English Heritage Trust (EHT) responses to Examining Authority's (ExA) Questions 2
26th July 2019

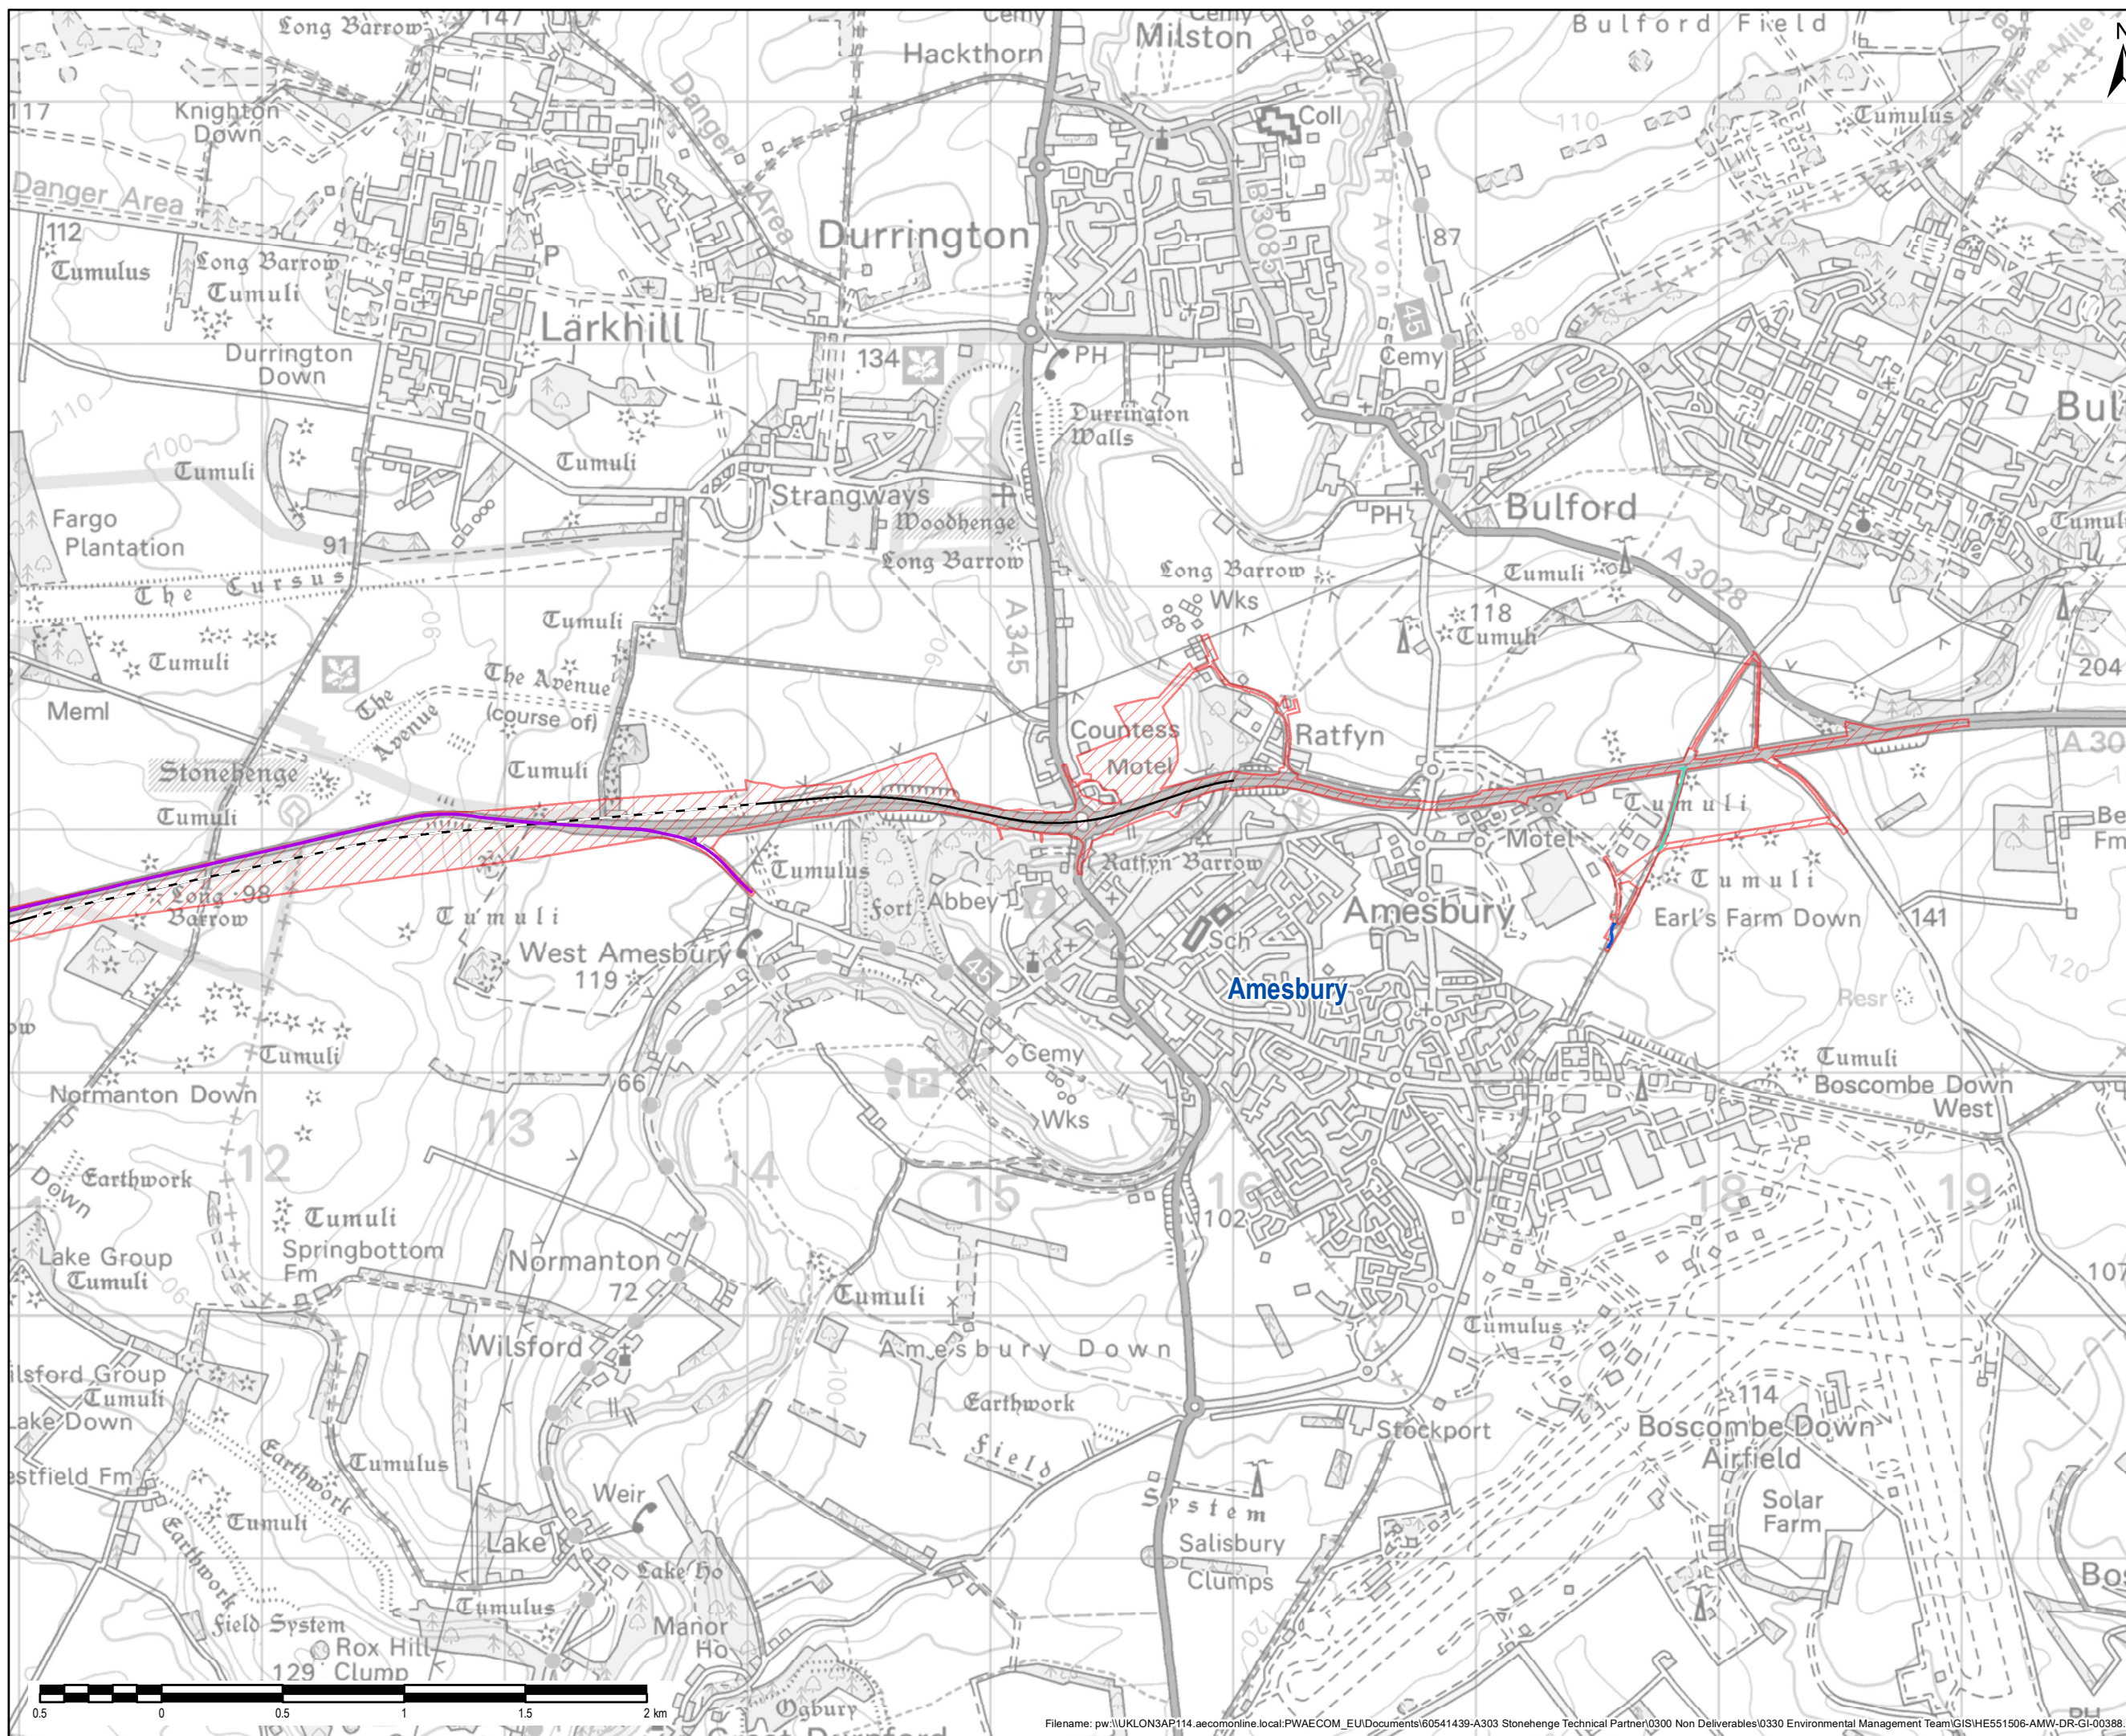
ExQ2	Question to:	Question:	EHT response:
CA.2.53	English Heritage	Please provide an update on the discussions as regards the proposed restricted byway running alongside the A360 within the boundary of the Stonehenge Visitor Centre complex and the exploration of alternatives.	<p>EHT continues to work with Highways England to discuss alternatives and measures to reduce where possible the risks we believe this new PROW introduces.</p> <p>Whilst we welcome the open and constructive dialogue with Highways England we remain concerned that alternative routes (that do not give rise to the risks highlighted in previous EHT Written Representations) are not being pursued. We understand this is because the most viable alternatives fall outside of the 'red line'.</p> <p>EHT understands that Highways England is focusing on amending the existing proposal to deliver, where possible, improvements to the current DCO proposal and we have provided feedback to Highways England on this.</p> <p>However, we remain concerned that our road safety concerns and operational impacts remain – even if attempts are being made to reduce them. Therefore our objection is maintained.</p>
